Application Ref:	2025/0373			 Ribble Valley Borough Council www.ribblevalley.gov.uk
Date Inspected:	16.5.25	Site Notice:	16.5.25	
Officer:	Stephen Kilmartin			
DELEGATED ITEM FILE REPORT:				APPROVAL

Development Description:	Advertisement consent for 1 fascia sign and 1 double sided non-illuminated projecting sign to the front elevation.
Site Address/Location:	Ethos House 4 York Street Clitheroe BB7 2DH

600mm x 600mm double sided illuminated projecting sign

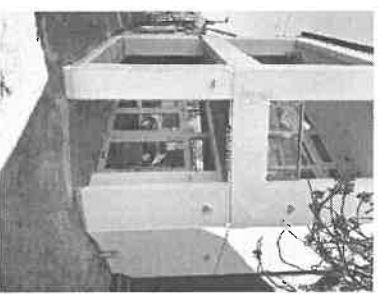
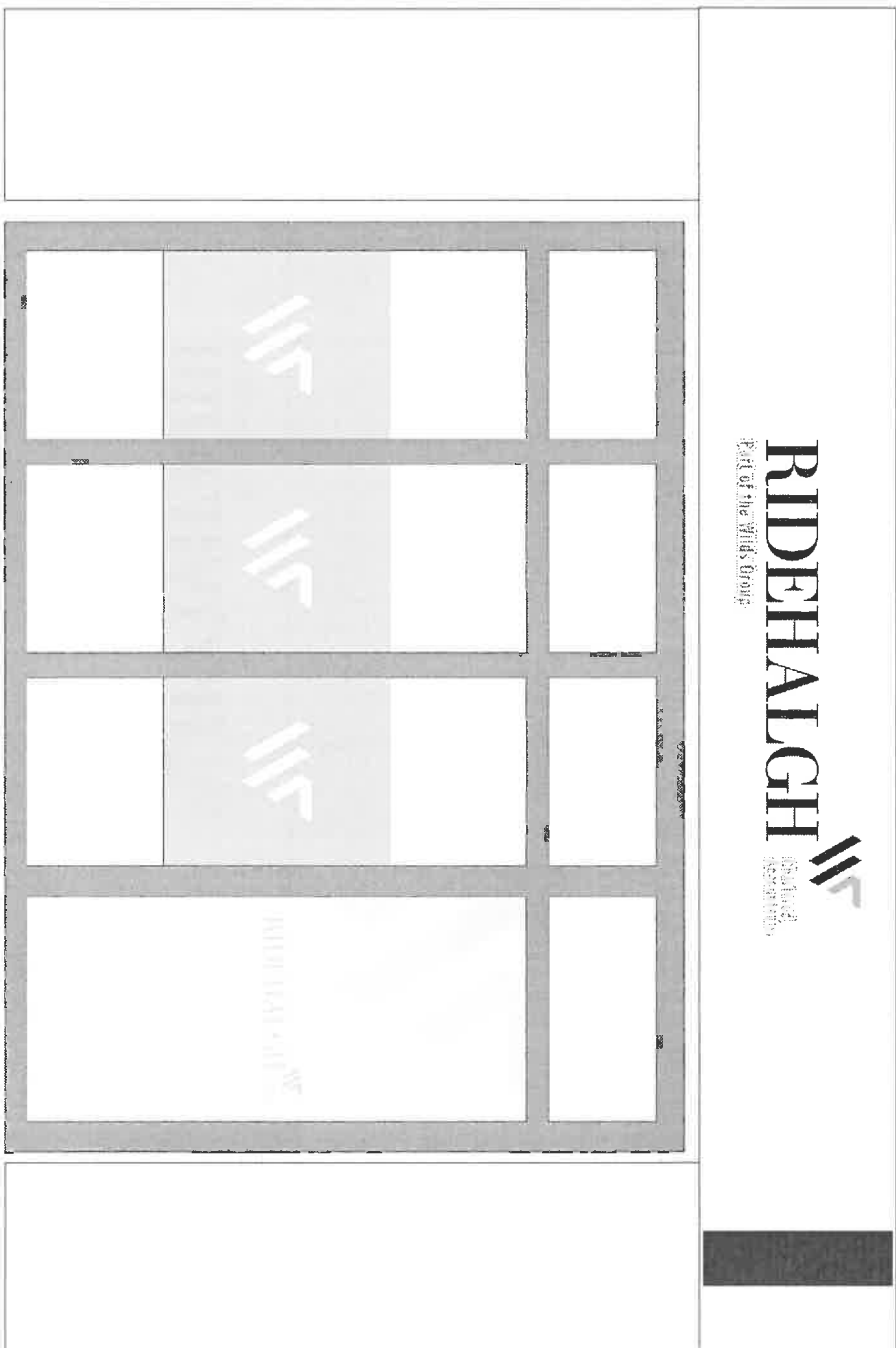
The proposed projecting signage will replace an existing projecting sign located on the front elevation of the property, with the signage being of a similar scale to that of the previous configuration. Following officer concerns in respect of the sign being internally illuminated, the agent has agreed that the lighting element of the signage will not be connected and as such will no longer be internally illuminated. As such, taking into account the projecting signage is of a similar scale to that of the previous configuration, also being of a scale that is commensurate with other such signage in the areas, it is not considered that the signage will result in any adverse measurable visual impacts upon the character or visual amenities of the Designated Clithero Conservation Area.

The proposed projecting signage will replace an existing projecting sign located on the front elevation of the property, with the signage being of a similar scale to that of the previous configuration. Following officer concerns in respect of the sign being internally illuminated, the agent has agreed that the lighting element of the signage will not be connected and as such will no longer be internally illuminated.
